# CITY OF ALBUQUERQUE

March 27, 2024

**RE: NM Boys & Girls Ranch  
Grading and Drainage Plan  
Engineer's Stamp Date: 03/18/24  
Hydrology File: D13D019**

Based upon the information provided in your submittal received 03/15/2024, the Grading & Drainage Plan **is not** approved for Building Permit and Grading Permit. The following comments need to be addressed for approval of the above referenced project:

ENGINEER'S SEAL	NM BOYS & GIRL RANCH ALBUQUERQUE, NM	DRAWN BY AS
RONALD R. BOHANNAN PROFESSIONAL ENGINEER 7868	GRADING & DRAINAGE PLAN	DATE 03-18-2024
5571 MIDWAY PARK PLACE NE ALBUQUERQUE, NM 87109 (505) 858-3100 www.tierrawestllc.com	TIERRA WEST, LLC	SHEET # C1
03/18/2024		JOB # 2023121

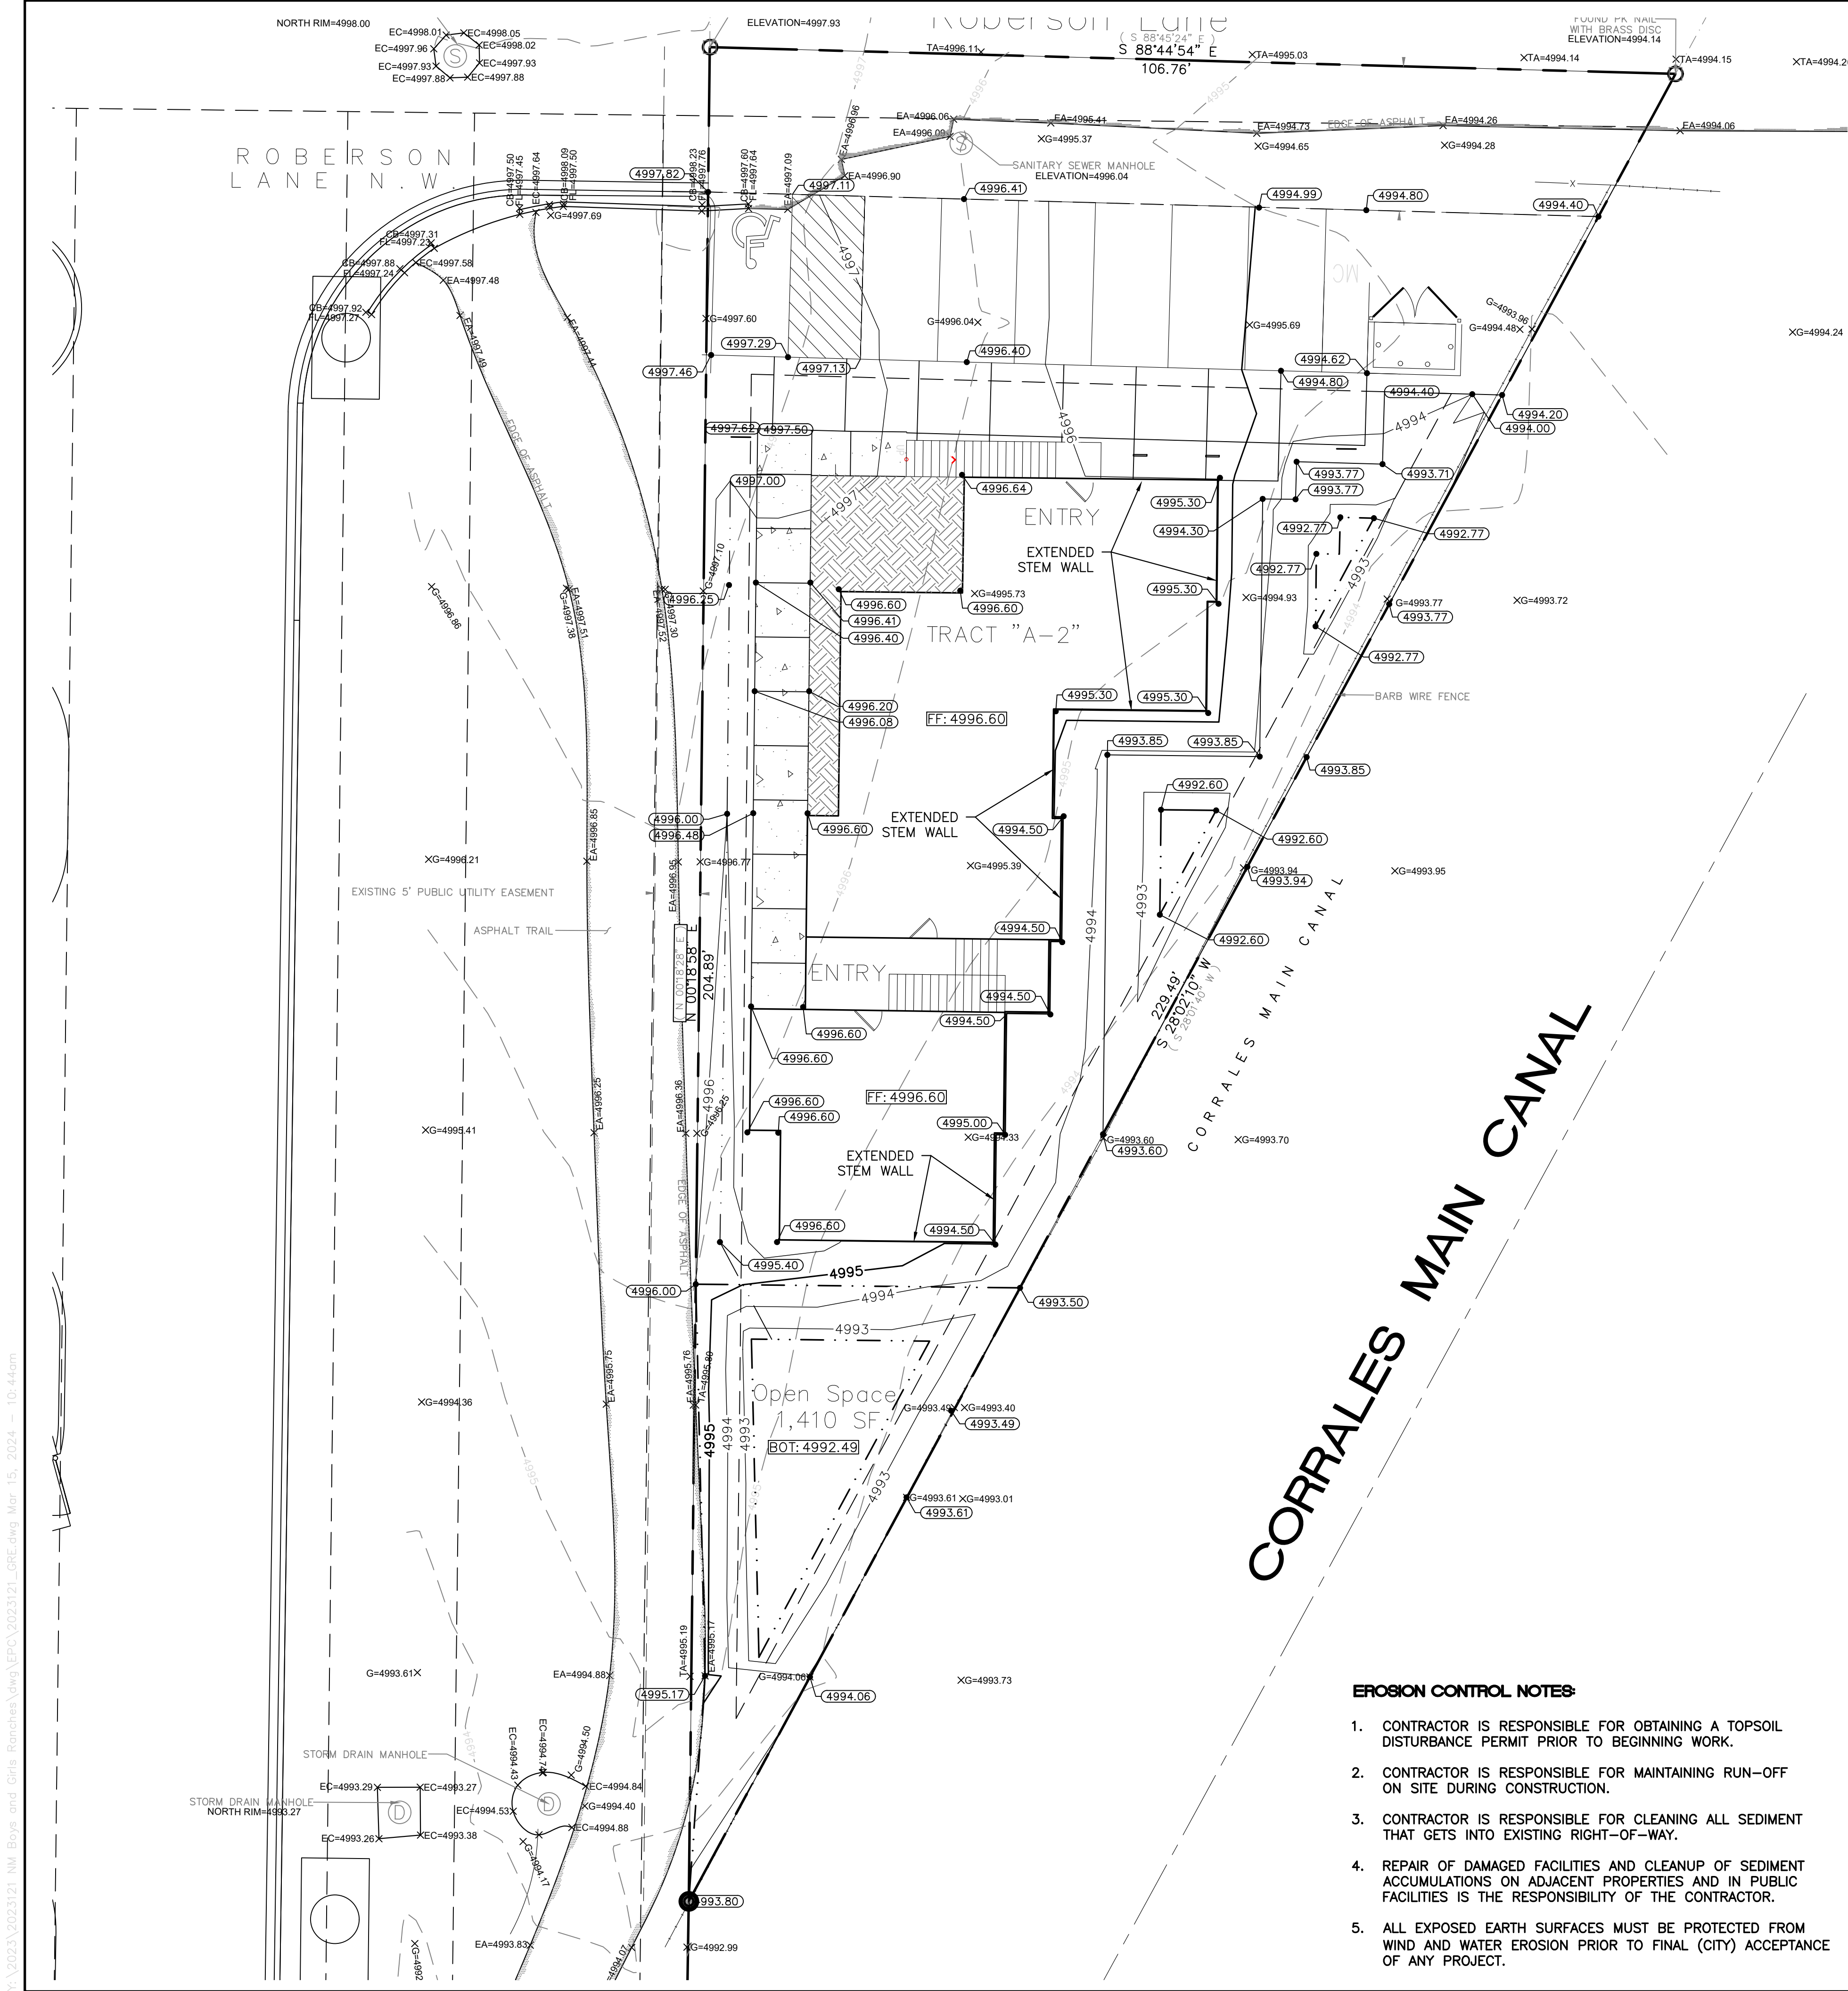
3. Please adjust the ponds to not only detain the difference between the proposed sites discharge of 1.37 and the allowable rate of 0.87 cfs, but also the required Stormwater quality pond volume for a new developed site. SWQ volume is equal to new impervious area (building, paving and sidewalks) in square feet \* 0.42 / 12 to give the required volume in cubic feet.

DRAINAGE MANAGEMENT PLAN:

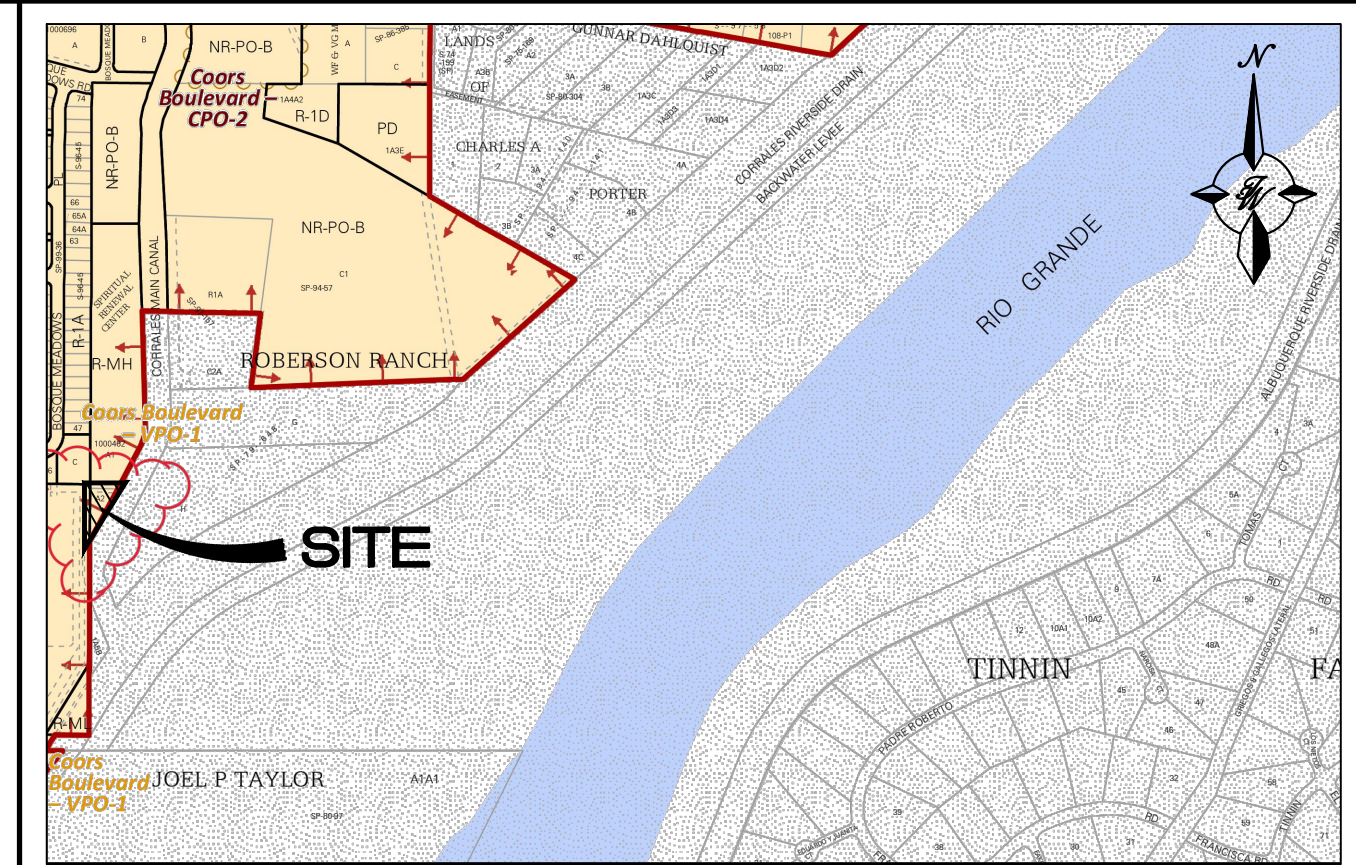
2. The whole Drainage Management Plan section is incorrect and appears to be just copied from a previous project. This site is part of the North Coors DMP – Middle Area done by Smith Engineering dated Feb 1997. In this DMP this site is part of a 7.168 acre drainage area that can discharge only 26 cfs. Therefore the site can discharge 3.63 cfs/ac and since the site is only 0.87 acres, it can only discharge 0.87 cfs into the Corales Canal.
